ESTEBAN RODRIGUEZ SUBDIVISION REZONE MAP

ESTEBAN RODRIGUEZ
JUDGE ORR ROAD
PEYTON, CO 80831
496.25 ACRE REZONE PLAN - RR2.5

ESTEBAN RODRIGUEZ SUBDIVISION REZONE PLAN

SHEET NO.
RZP1.1

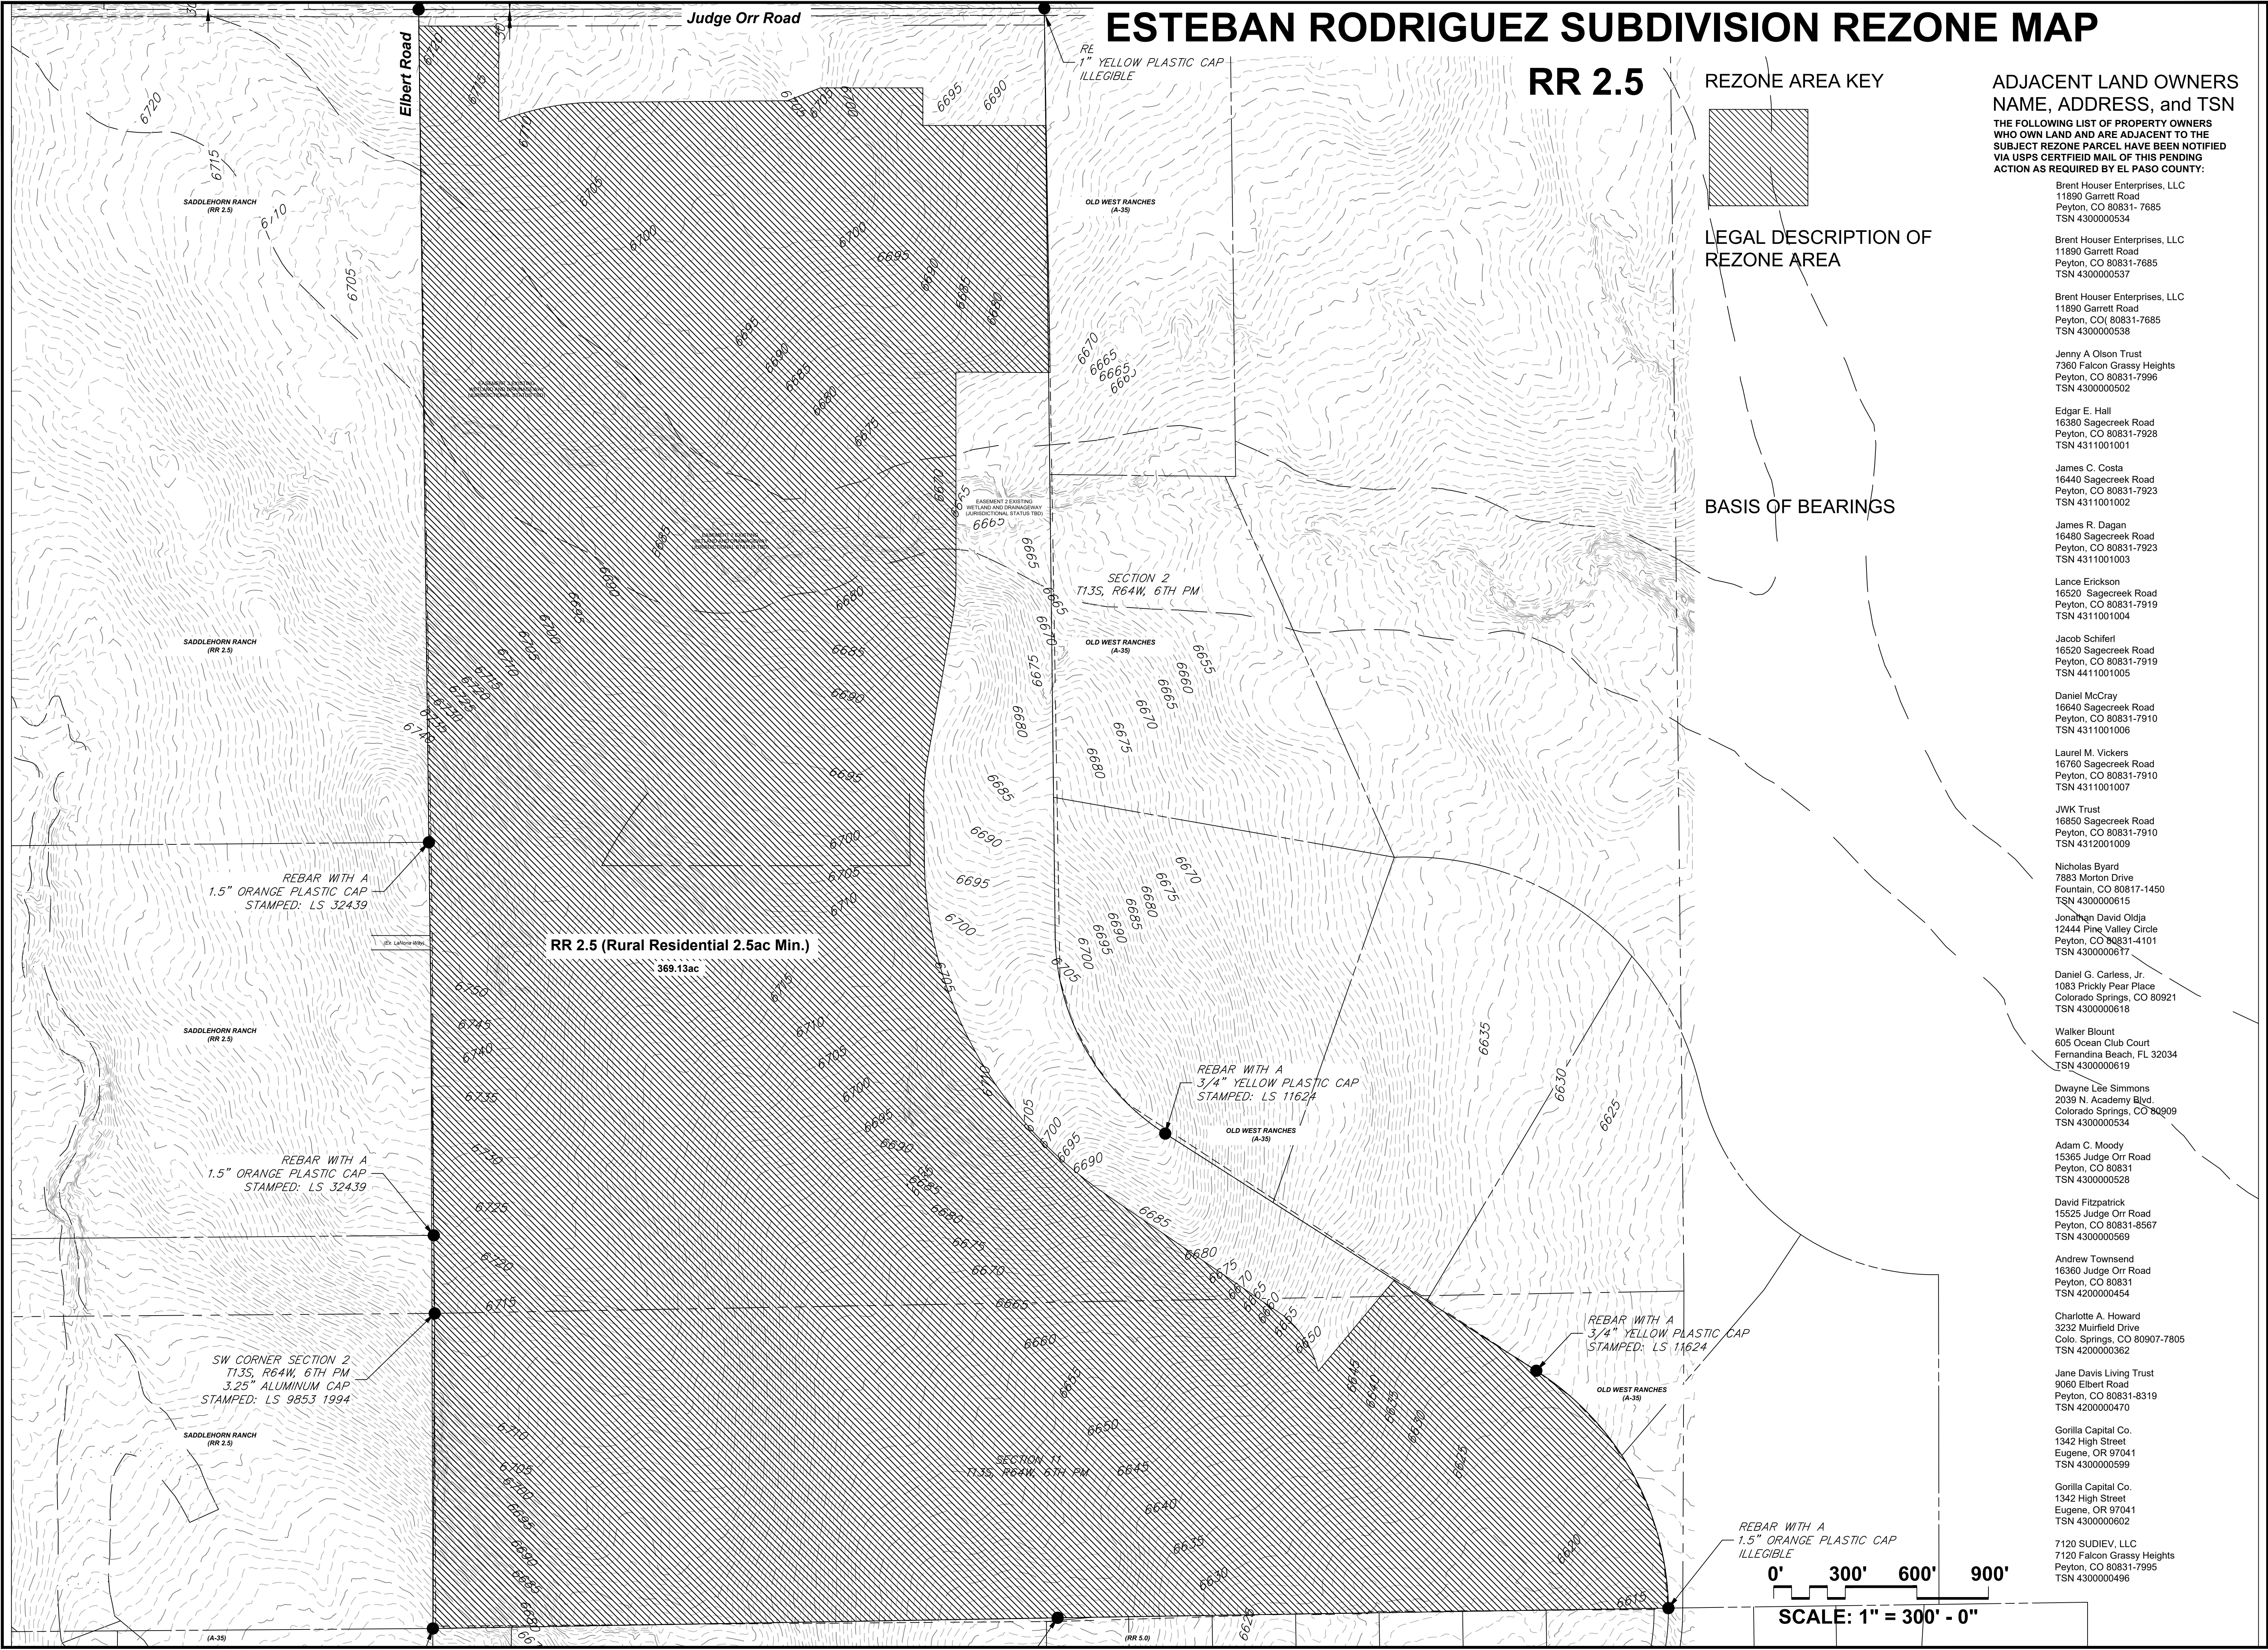
Please remove this page

SHEET NO.
RZP1.2

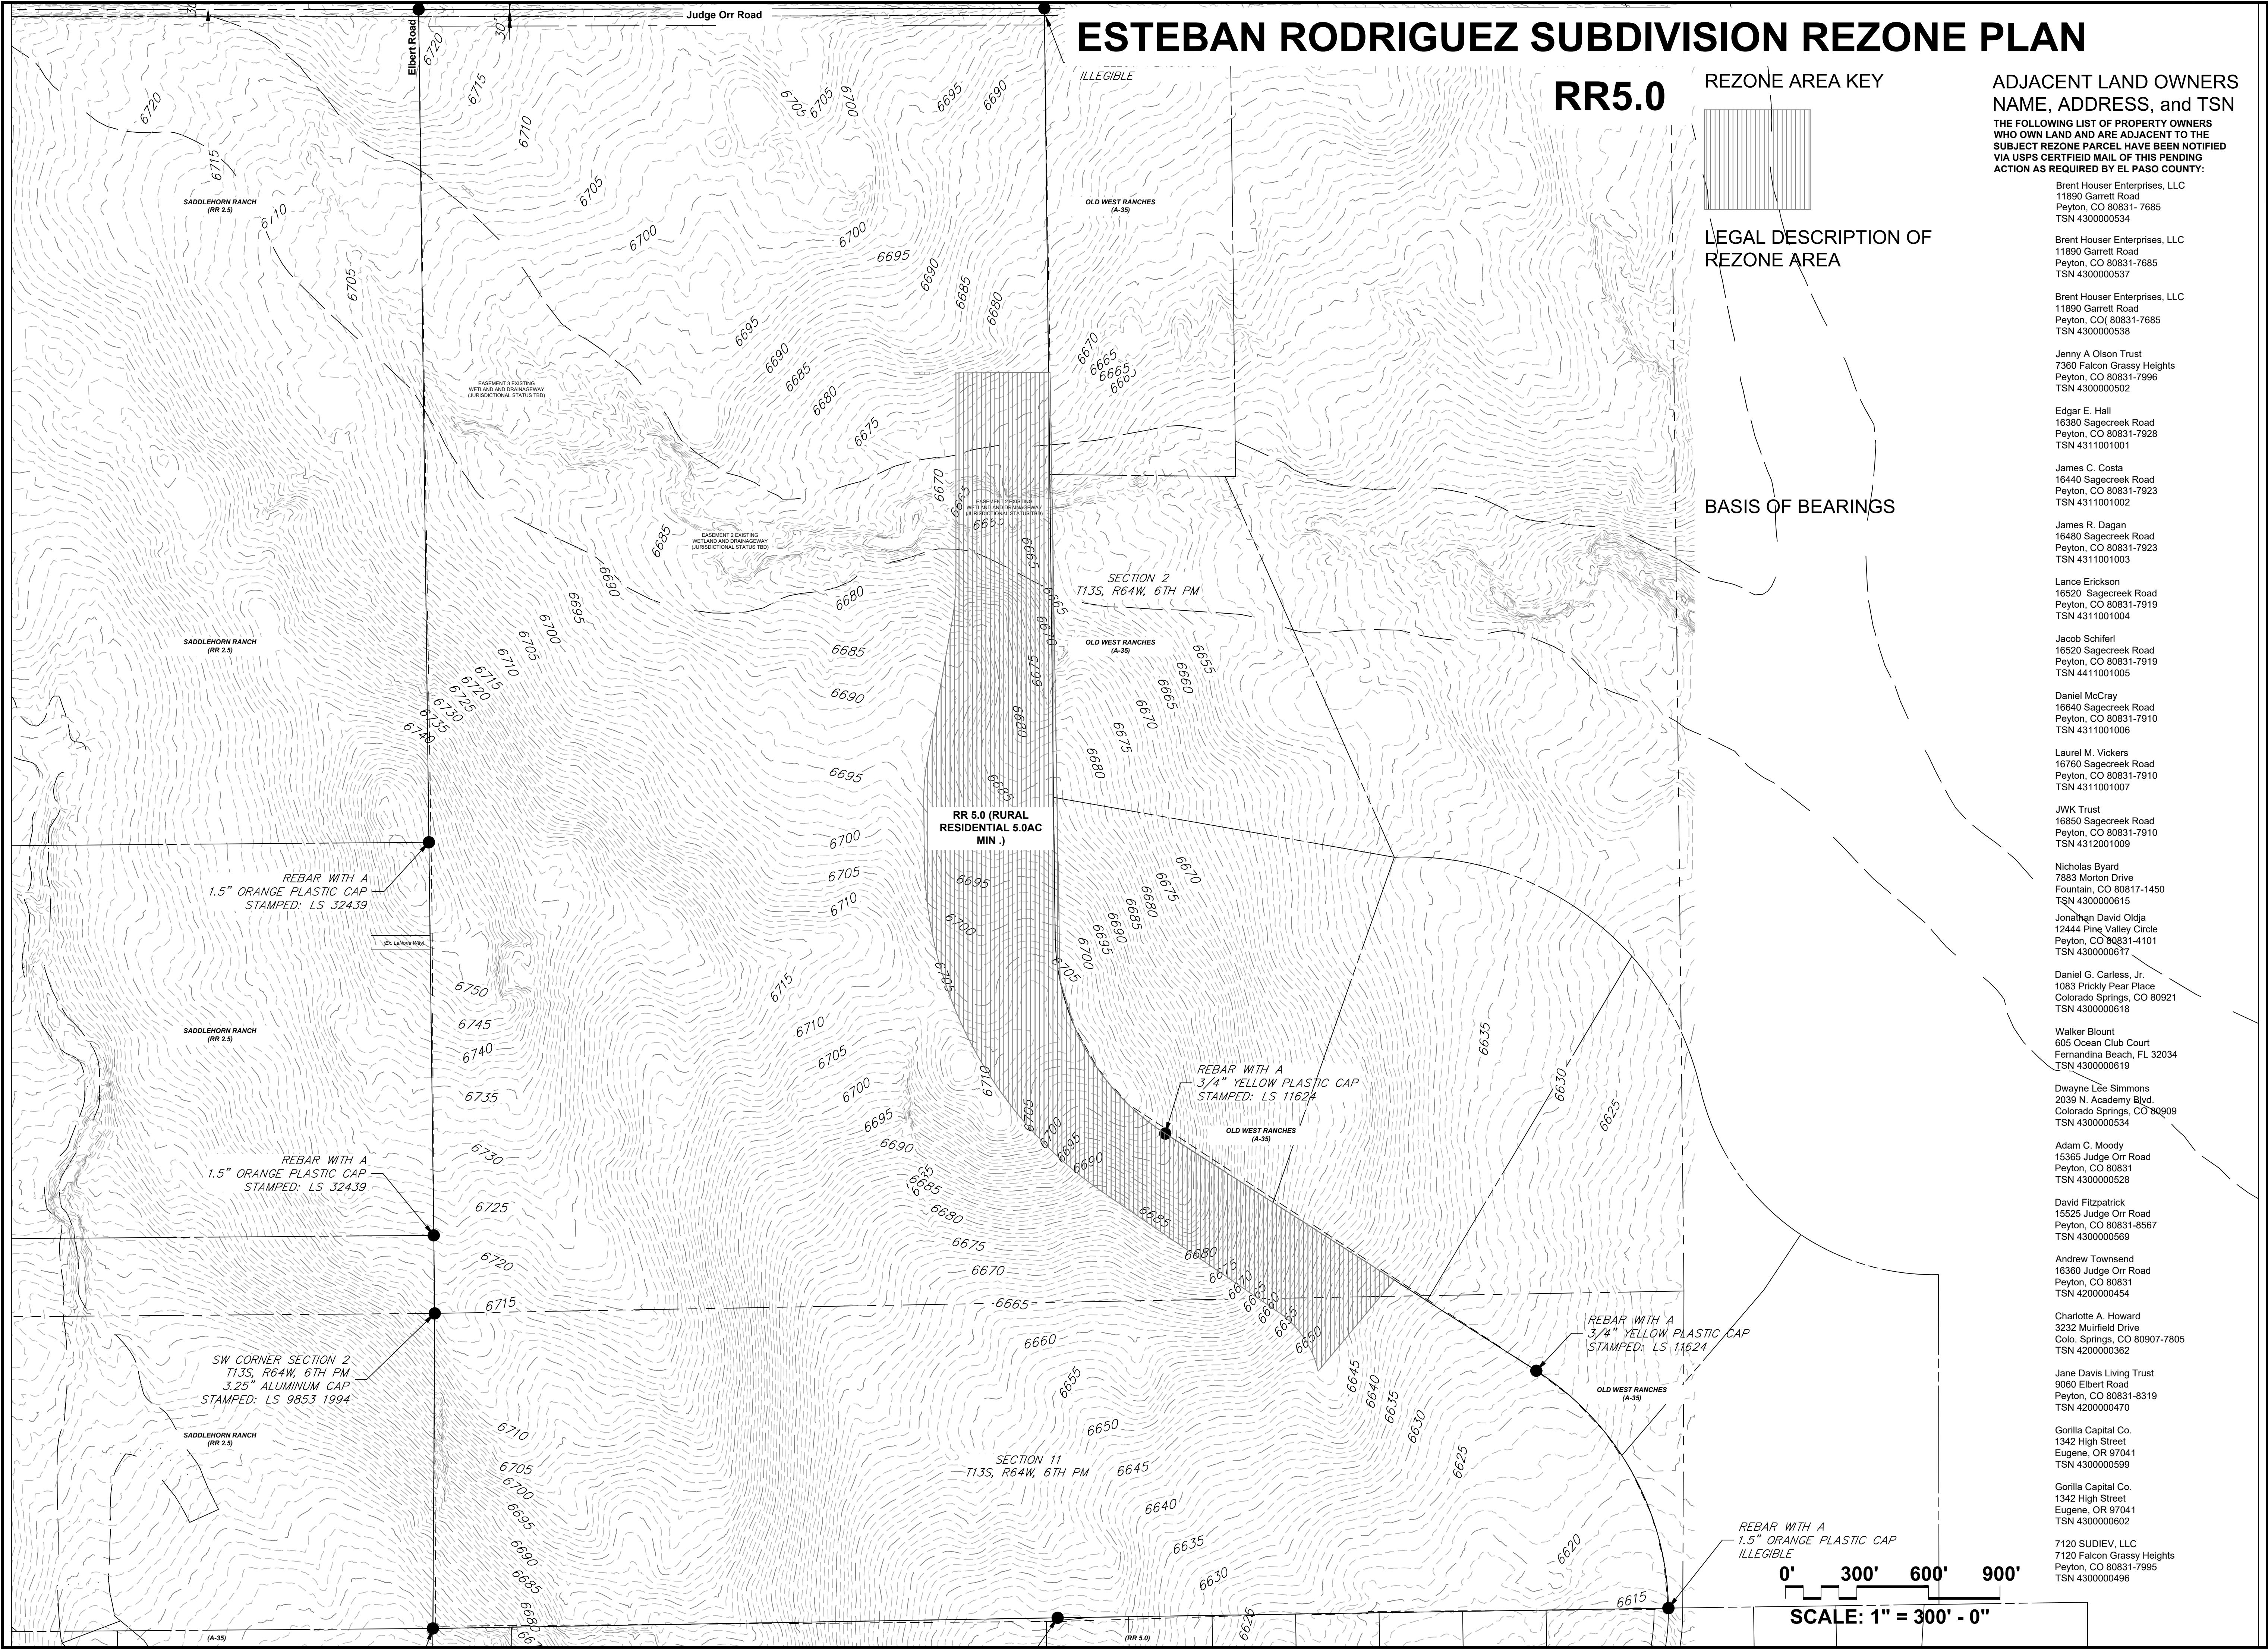
Parcels with an X:
-zoning
-land use
-ownership

Please remove

Please depict the lots that create this area, this makes it appear as though its one lot, and it is not

Please remove this page
